Rosefield Solar Farm (EN010158)

**Rosefield Solar Farm – Buckinghamshire Council's Comments
to the Applicant's Updated Deadline 1 Documents**

Buckinghamshire Council

April 2026

Plate 7.1: Proposed PRow diversions and permissive paths in Parcel 1

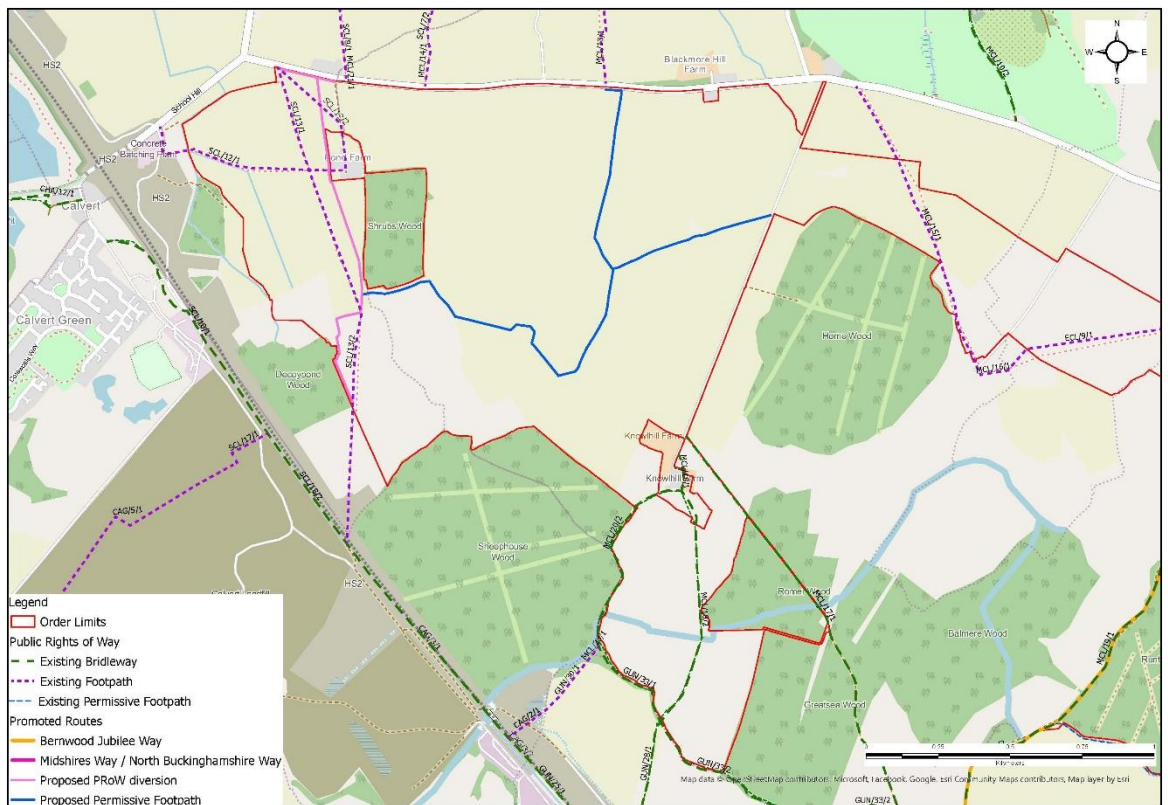
REP1-088	Rosefield Energyfarm Limited	7.7.2 Outline Soil Management Plan (Clean) (Rev 2)	<p>Soils and Agriculture: This document was updated to include this statement “(an experienced person who is trained by a soil specialist) at strategic locations where questions were raised over who would make key soil management decisions”. This is not a secure answer to the Council’s concerns due to its generic nature.</p> <p>Section 5.3.8 is updated to include a clearer statement on how existing land drainage will be managed when disrupted. Section 6.3.7 updated to cover how land drainage will be repaired after trenching. Overall these are minor updates and are not an overall change of position which resolves the Council’s concerns.</p>
REP1-090	Rosefield Energyfarm Limited	7.8.2 Outline Rights of Way & Access Strategy (RoWAS) (Clean) (Rev 2)	<p>Rights of Way: The text amendments which appear in blue are accepted, but, while it’s accepted there is a benefit connecting to SCL/8/1 with the new arrangement, the Council disagrees the revised footpath diversion for the deleted and created network north-west of Pond Farm in Parcel 1 is the best layout possible.</p>

Document Ref and Link	Author	Document Title	Buckinghamshire Council Comments
			<p>The proposed layout is below shown in document 2.4.3 and shown below.</p> <p>Two right-angle bends are created at point SW40 (left and right) which are unnecessary and inconvenient compared to the desire lines suggested in the Council's comments of Nov 2025. If the field is open, walkers will take the direct route anyway. The recommended plan is copied below, where green is created and black is deleted. The Council recommends a revised plan that reflects this proposal. The Council queries why can this not be provided when there are no solar panels in Field B5.</p> <p>It is also uncertain in the plan provided (STREETS, RIGHTS OF WAY AND ACCESS PLANS SHEET 1 OF 8 - EN010158/APP/2.4.3 March 2026) the distinction between pink lines and turquoise lines and which will appear on the definitive map, e.g. there is a pink line SW03 to SW04 passing along the vehicular access to Pond Farm. It is unclear what this represents. The key says, 'Street Works', but it is unclear what this means where this is drawn 1mm beside an existing or a new footpath.</p>
